PORTISHEAD BRANCH LINE – METROWEST PHASE 1

**Schedule of ExA's recommended amendments to the Applicant's draft DCO
submitted at Deadline (D)6 [REP6-008]**

Drawing
PORTISHEAD STATION CAR PARK
LAYOUT, LANDSCAPING AND NEW
BOULEVARD AND ACCESS PLAN
SHEET 2 OF 3

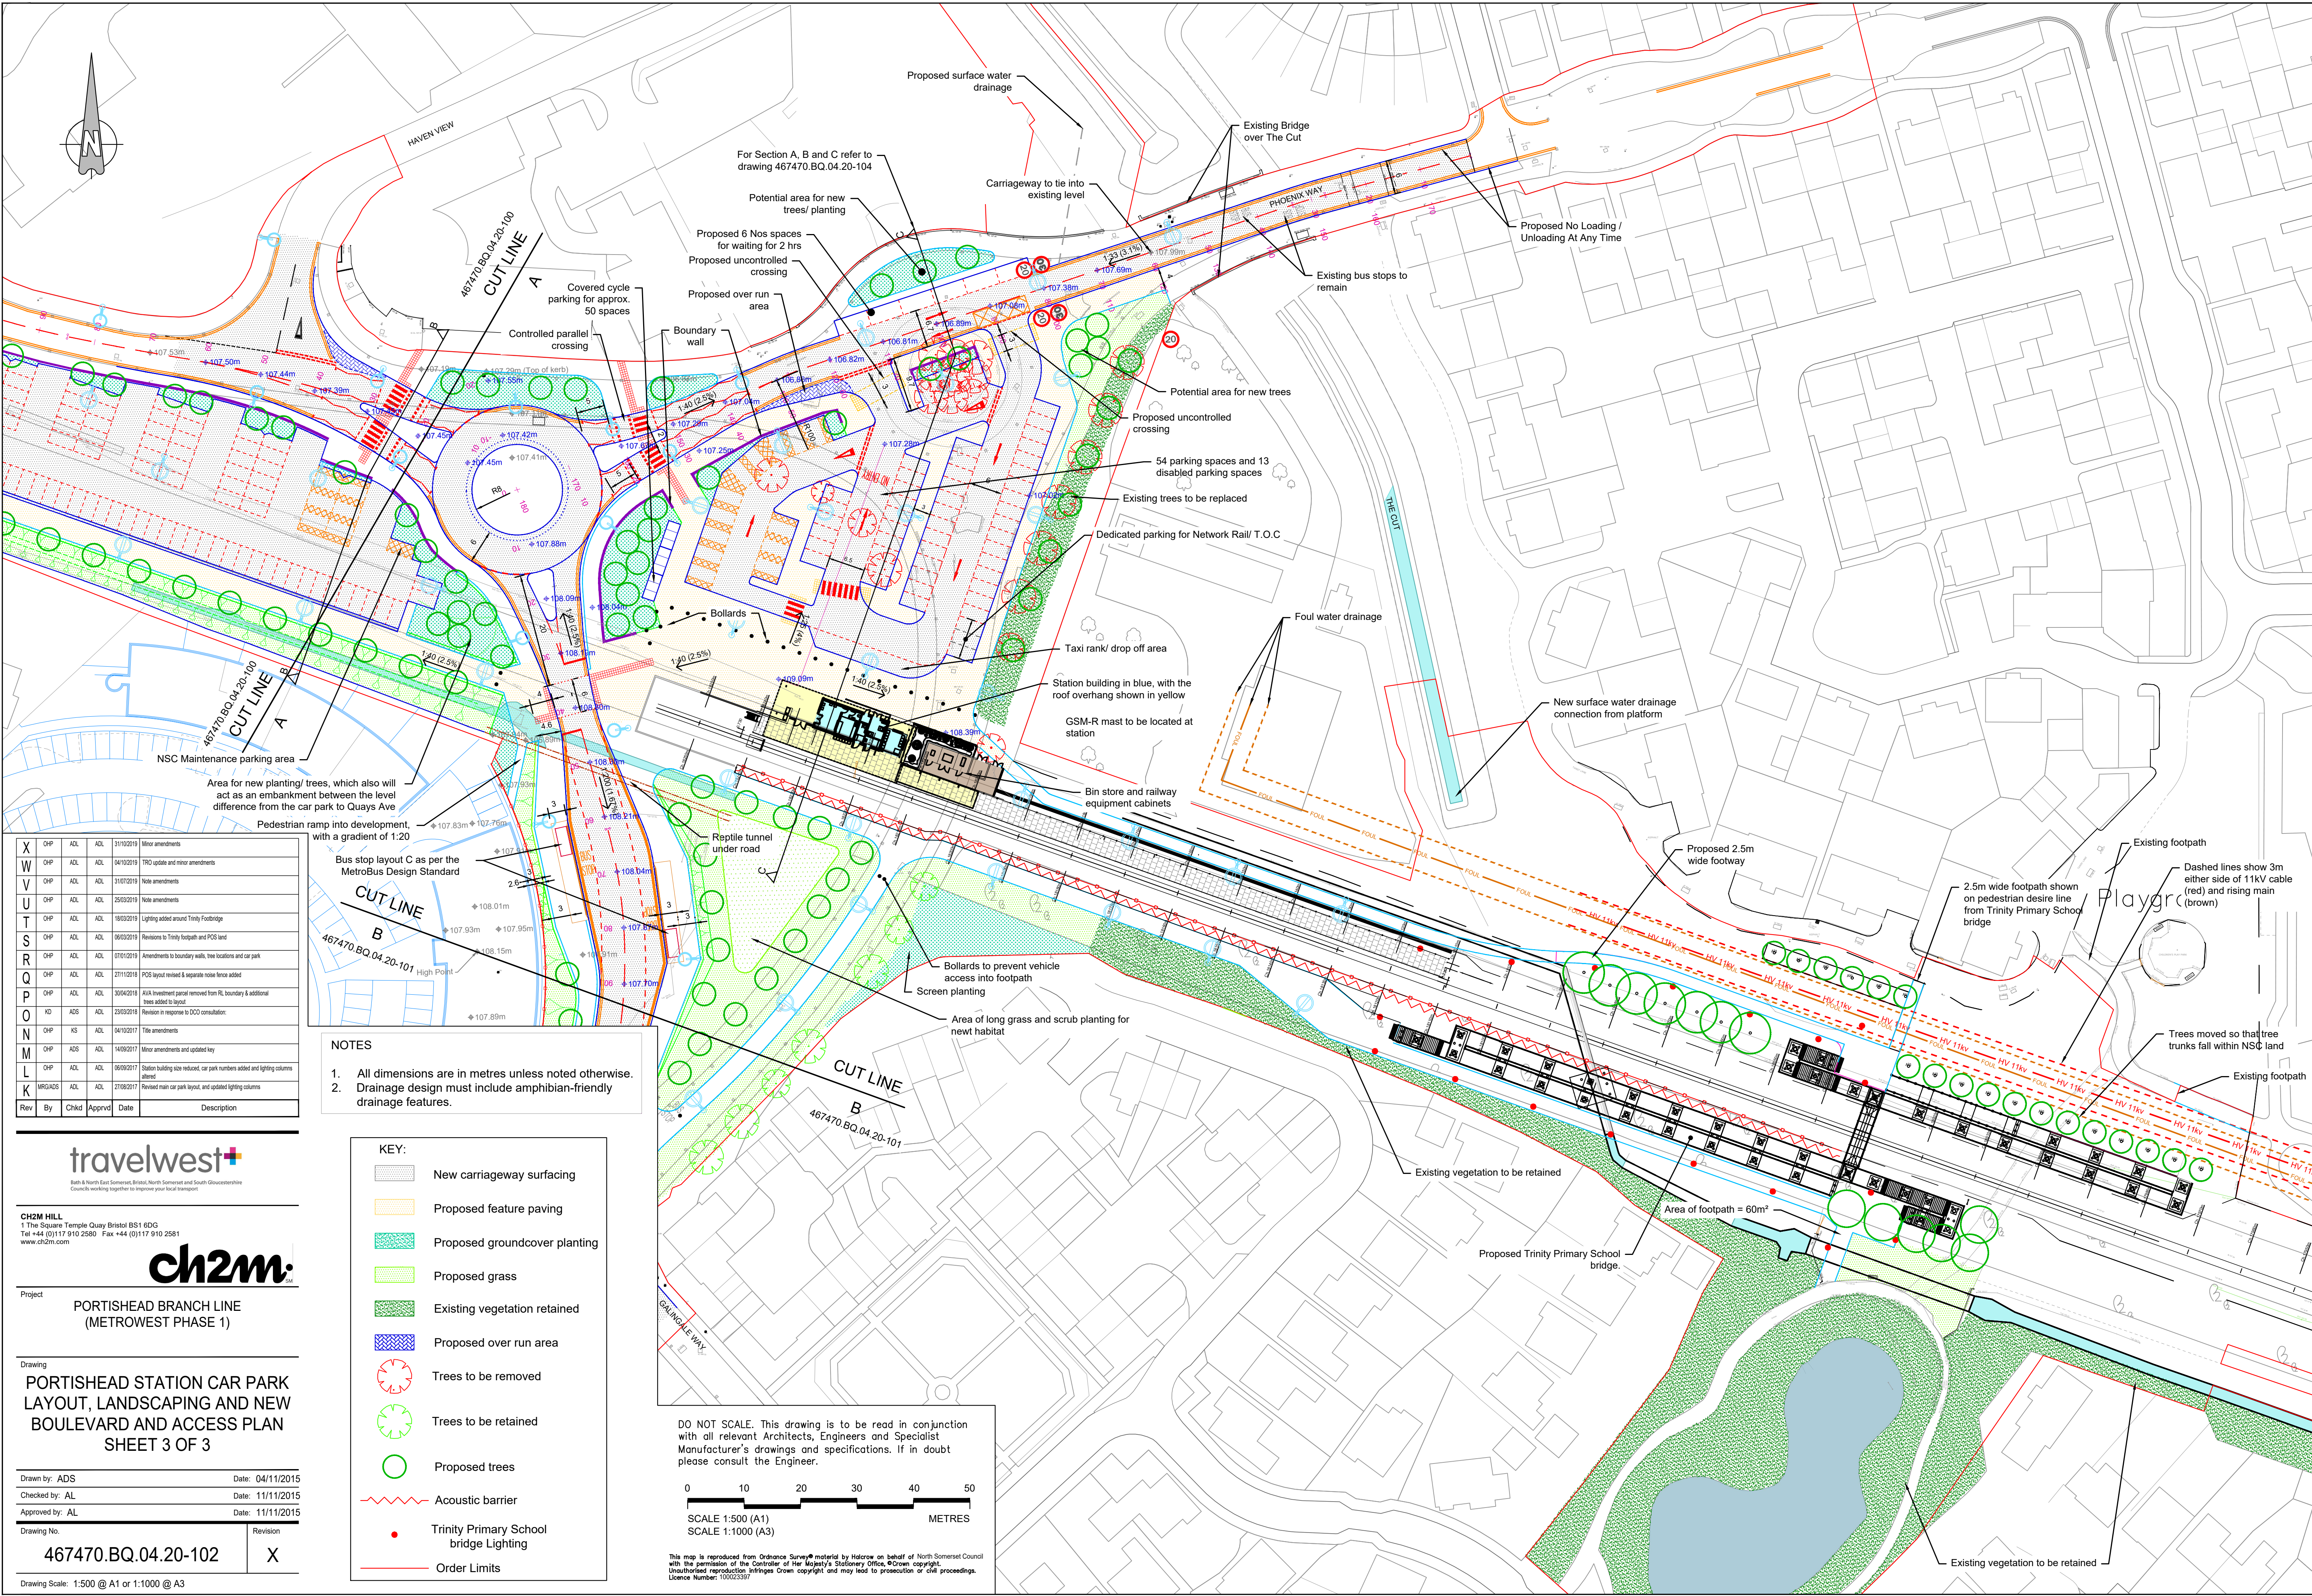
<p>Schedule 2 New Requirement <i>Trinity Primary School Bridge</i></p>		<p>(1) Work No 7 must not commence until details of any permanent lighting to be installed in connection with that work, including measures to minimise light spillage, have been submitted to and approved by the relevant planning authority.</p>	<p>Whilst the ExA note that the submission and approval of detailed design for Trinity Primary School Bridge (Work No 7) would be delivered under Requirement 4 the ExA consider that as for other elements of the scheme (eg Portishead Station which is also included in Requirement</p>

<p>(2) Work No 7 must not commence until details of the colour finish of the bridge have been submitted to and approved by the relevant planning authority.</p> <p>(3) Work No 7 must not commence until details of the location, design and colour of privacy screens, if required, have been submitted to and approved by the relevant planning authority.</p> <p>(4) Work No7 must be carried out in accordance with the approved details and thereafter permanently retained.</p>	<p>4) should the Secretary of State (SoS) grant consent then given the concerns raised during the Examination in relation to this work it is important that details in relation to permanent lighting; colour of the bridge and location, design and colour of privacy panels for the bridge are submitted for approval</p>
<p>Schedule 2 New Requirement <i>Perimeter Track between Marsh Lane and the compounds under the M5 Avonmouth Bridge and on Lodway Farm</i></p>		<p>(1) Work Nos 16A and 17 must not commence until:</p> <p>(a) a pre-commencement survey of the perimeter track between Marsh Lane and Work Nos 16A and 17 has been undertaken and submitted to and approved by the relevant planning authority. The pre-commencement survey shall include but not be limited to:</p>	<p>The ExA consider that should the SoS grant consent the use of the perimeter track to access Work Nos 16A and 17 should not result in damage to this track and the track itself should be capable of accommodating the weight and volume of construction traffic that would need to use it</p>

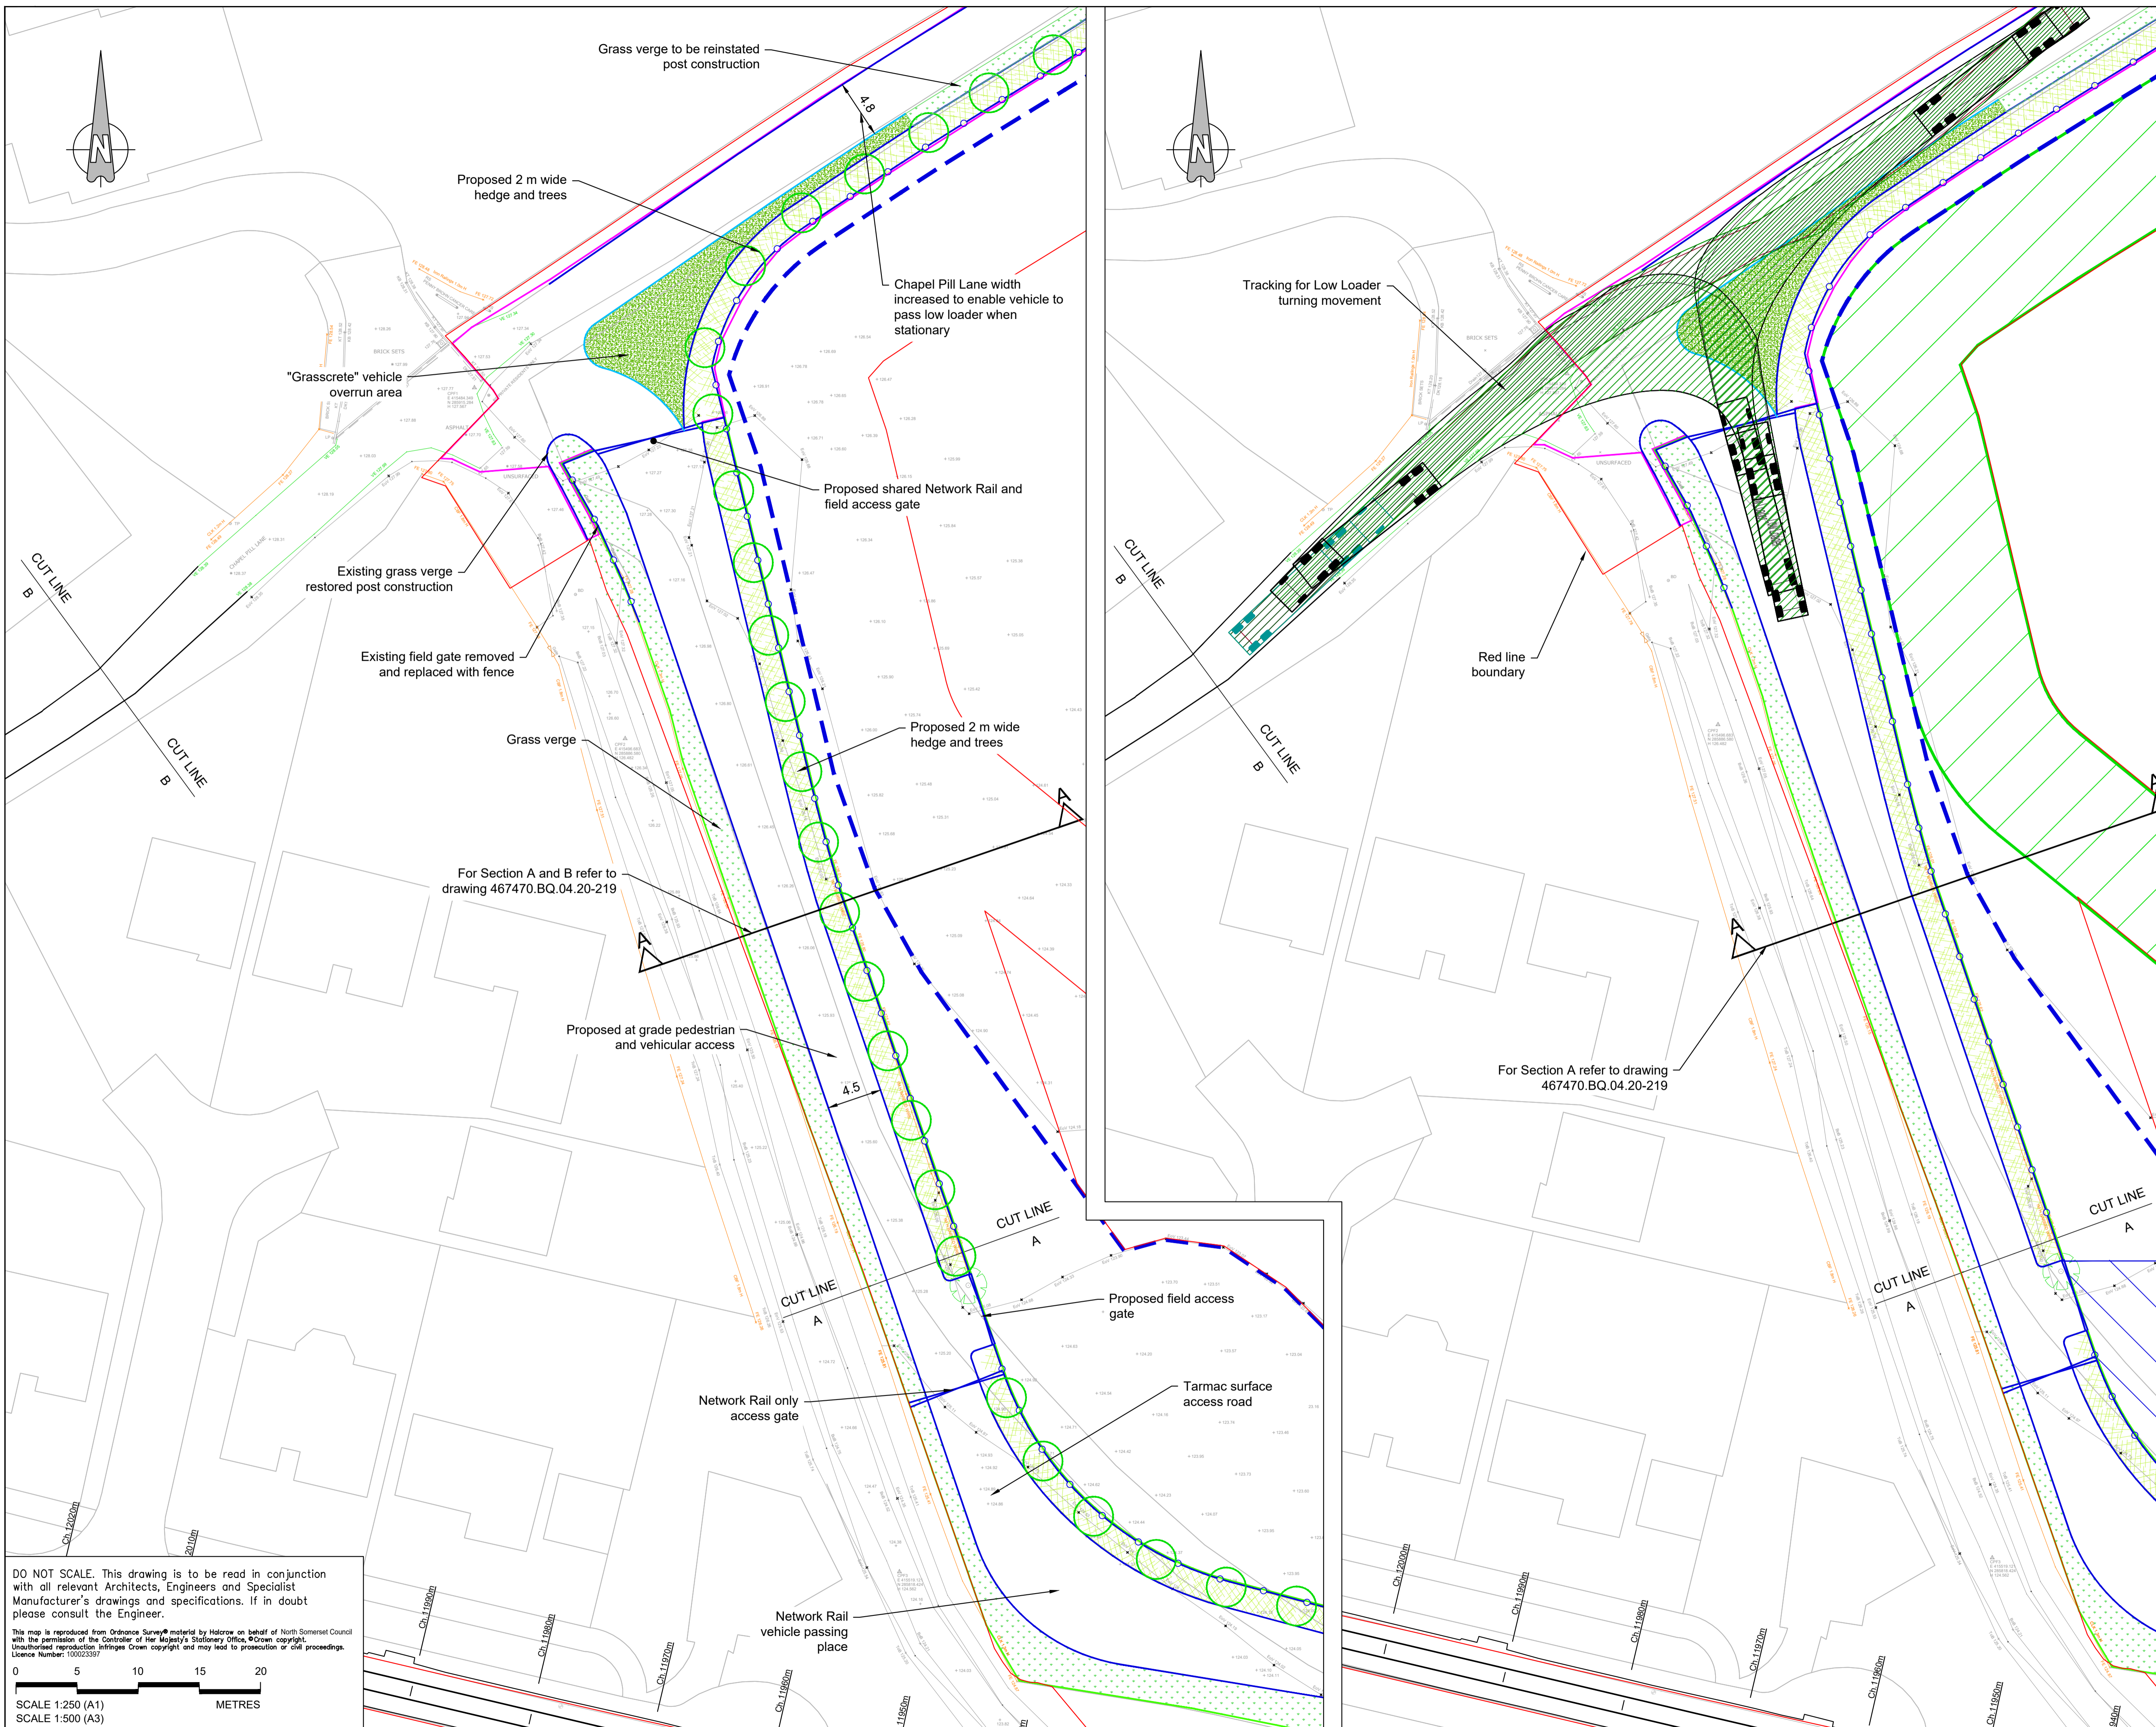
measures/ repairs that would be required.	
Schedule 2 New Requirement <i>Pill Tunnel Eastern Portal Compound Access, Ham Green</i>		<p>Work No 24 must not commence until written details of the levels and surfacing of the Work have been submitted to and approved by the relevant planning authority. Work No 24 must thereafter be carried out and retained in accordance with the approved details.</p>	<p>Whilst the ExA note that the submission and approval of detailed design for the Pill Tunnel Eastern Portal Compound (Work No. 24) would be delivered under Requirement 4 the ExA consider that as for other elements of the scheme (eg Portishead Station which is also included in Requirement 4) should the SoS grant consent then given the concerns raised during the Examination in relation to this work and its location in the Green Belt it is important that details in relation to surfacing and levels are submitted for approval</p>
